**MetroLink**

## **Additional Errata Relating to Chapter 20**

Document Title: Additional Errata Relating to Chapter 20

**METROLINK**

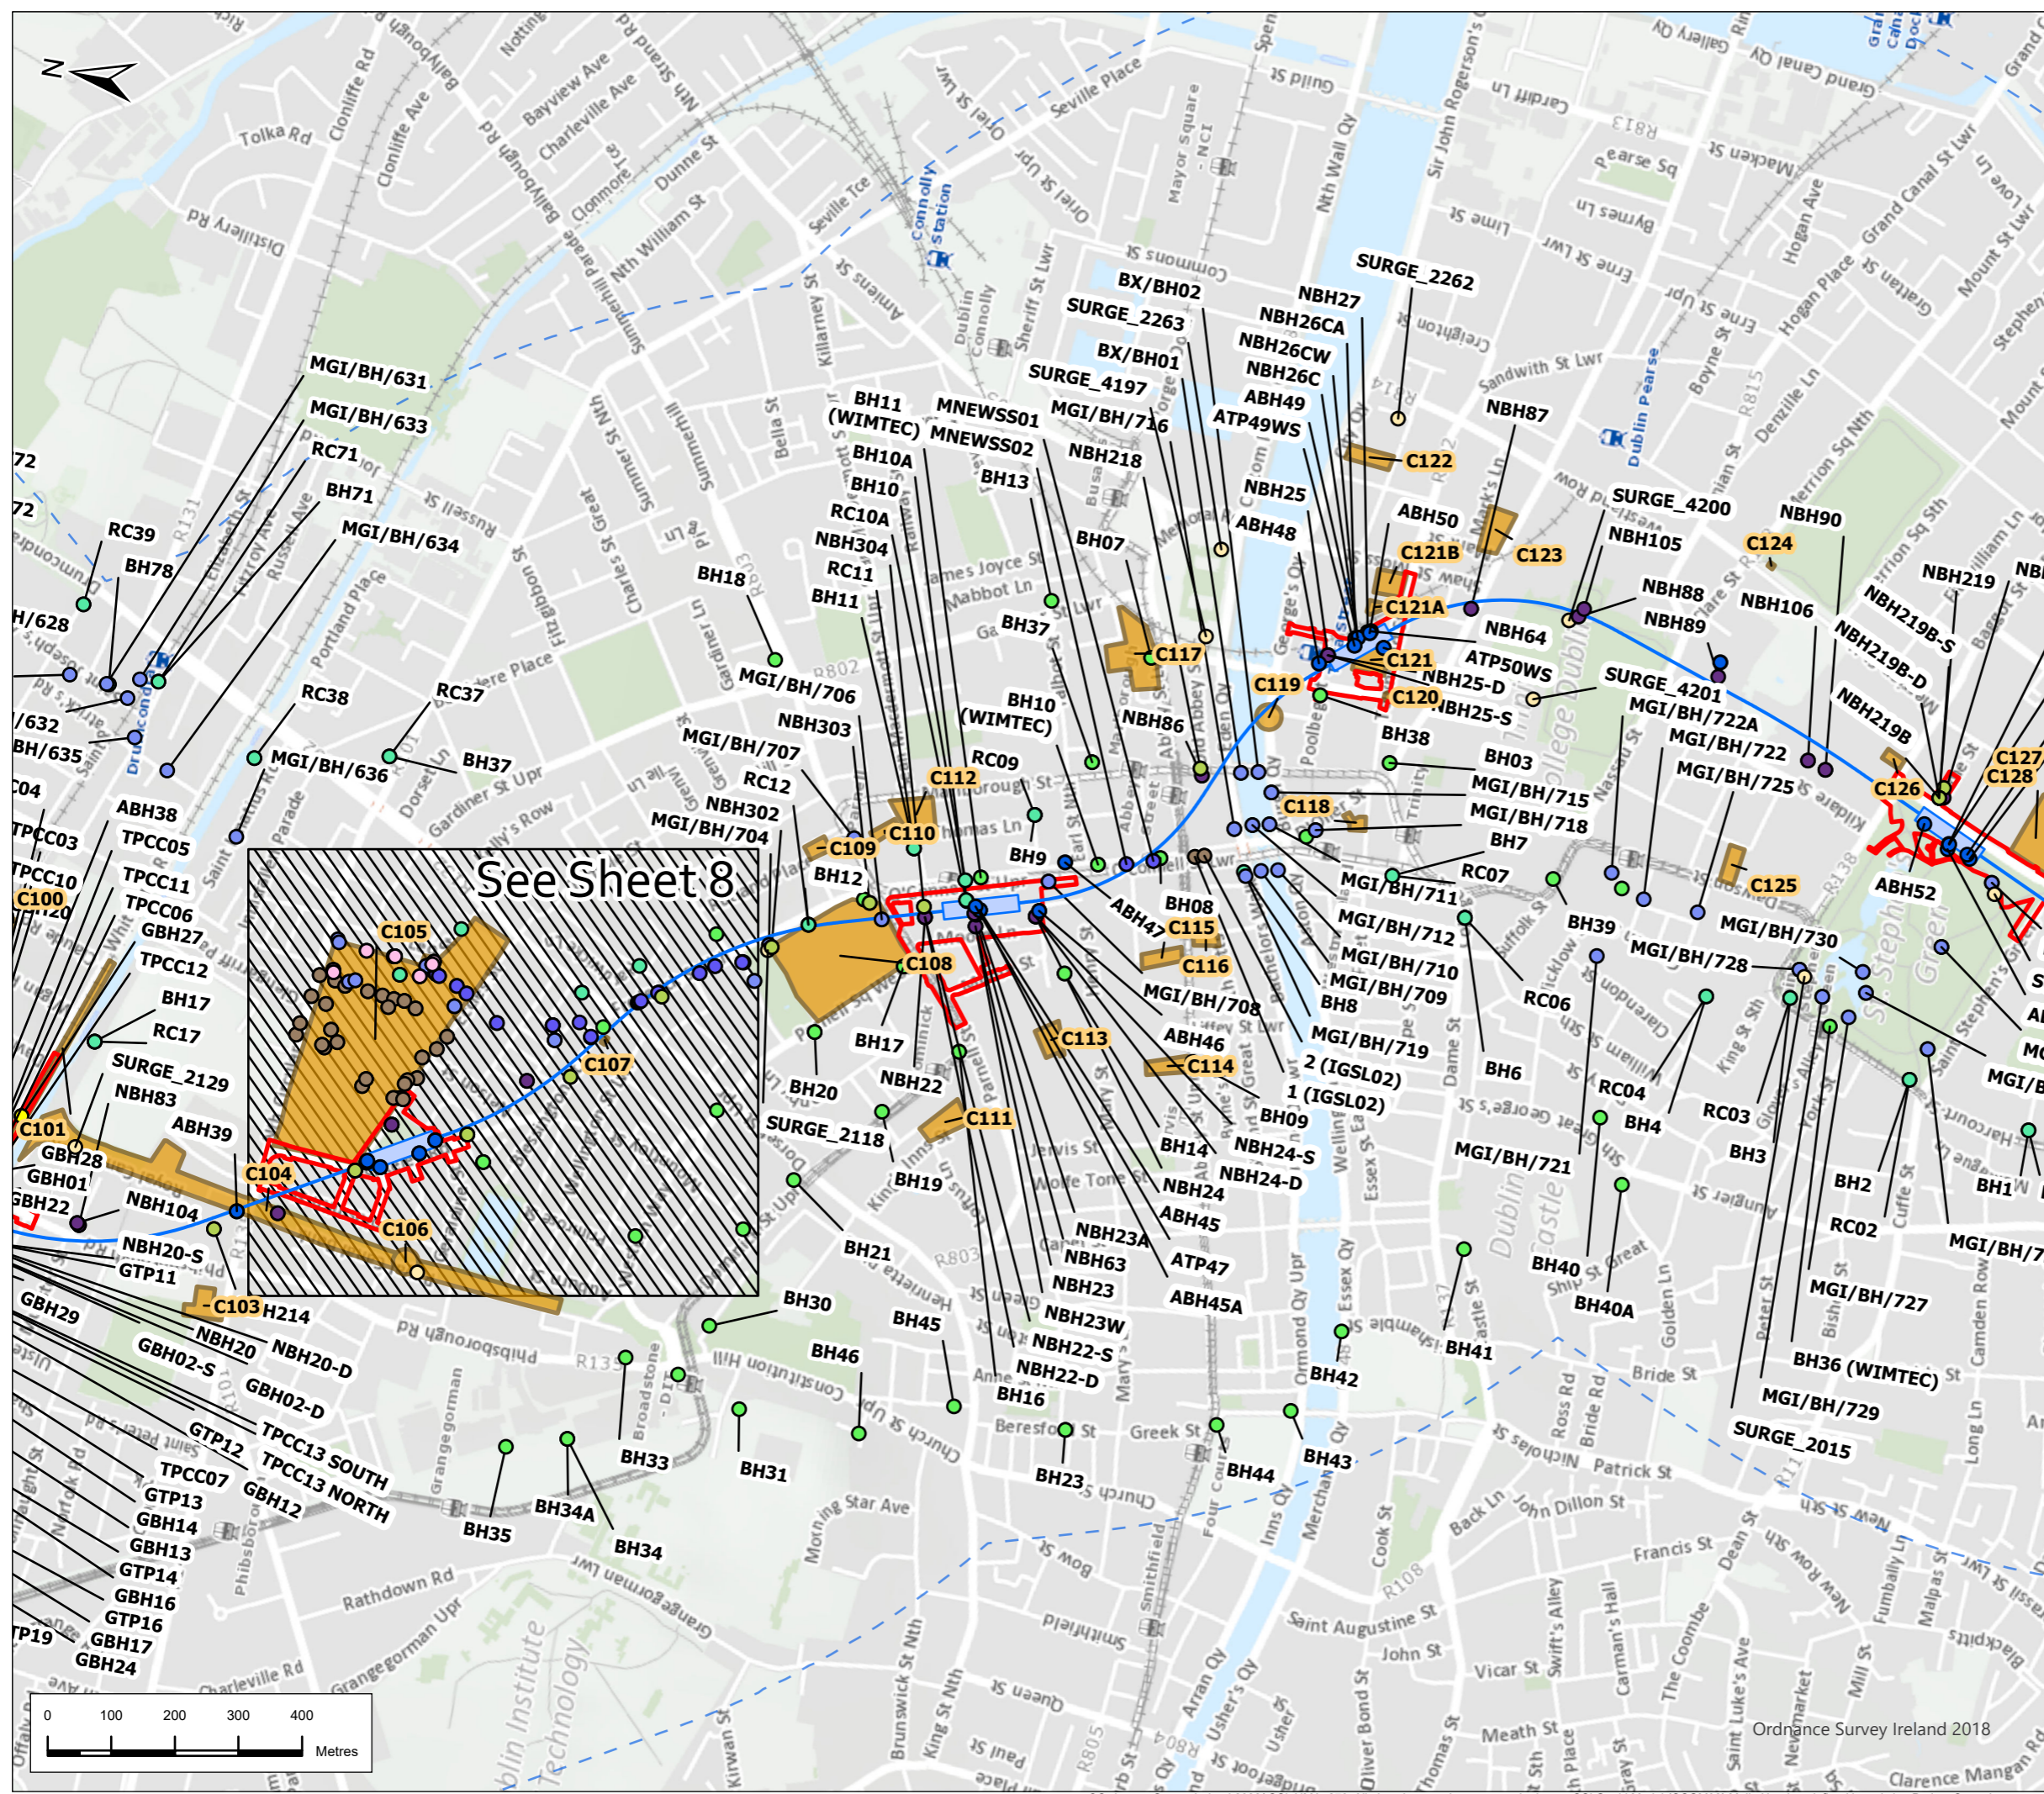
It has become clear during the course of the oral hearing that, in error, borehole locations which appeared in an early drawing of proposed bore hole locations, and which did not form part of the Geotechnical Investigation (GI) scope, were included in error in the chapter presentation as follows:

- Figure 20.6 (Revised version attached)
- Appendix A20.1 (Summary of Supporting Ground Investigation Scope)
- Appendix A20.2 (Summary of Relevant Exploratory Hole Locations and Monitoring data)
- Appendix 20.8 (Appendix A Tables A1 to A4) and Figure 20.6.

Chapter 20 includes summaries of the ground investigation (GI) data used in development of the assessment as detailed above as well as a figure detailing the GI locations. An error has been identified whereby proposed borehole locations which were not actually drilled were included in the summary tables detailed above and Figure 20.6. These borehole locations were not drilled as they were not required. The proposed Phase 1 borehole references included in error are listed in Table 1.

The inclusion of these proposed GI location references was mistaken, and it should be noted that boreholes at these proposed GI locations were not drilled. Consequently, there is no data associated with these proposed locations.
